From: Sue Howell <Sue.Howell@arun.gov.uk>
Sent: 09 October 2019 17:34
To: Planning.Responses <Planning.Responses@arun.gov.uk>
Cc: Michael Eastham <Michael.Eastham@arun.gov.uk>
Subject: FW: Planning Consultation on WA/96/19/DOC

Comment from Greenspace

APPLICATION NO: WA/96/19/DOC

Description of Works: Approval of details reserved by conditon imposed under ref
WA/44/17/OUT relating to Condition No 11 - landscaping.

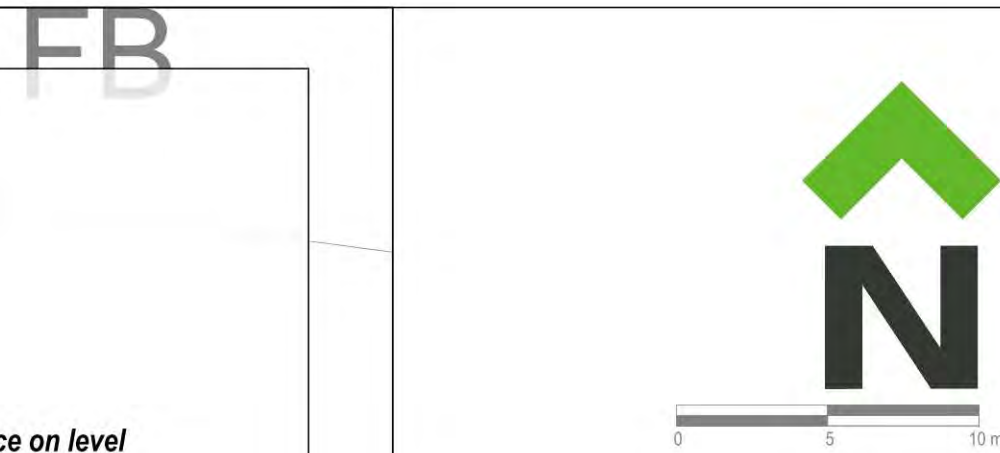
The detail has also now included consideration of the ball stop netting adjacent to the golf course, which whilst would not disguise this, will go somewhere over time to softening the impact of this. There has been the inclusion of mature tree planting in this location which has a greater opportunity as it establishes to detract the eye, whilst allowing important views through to the golf course beyond.
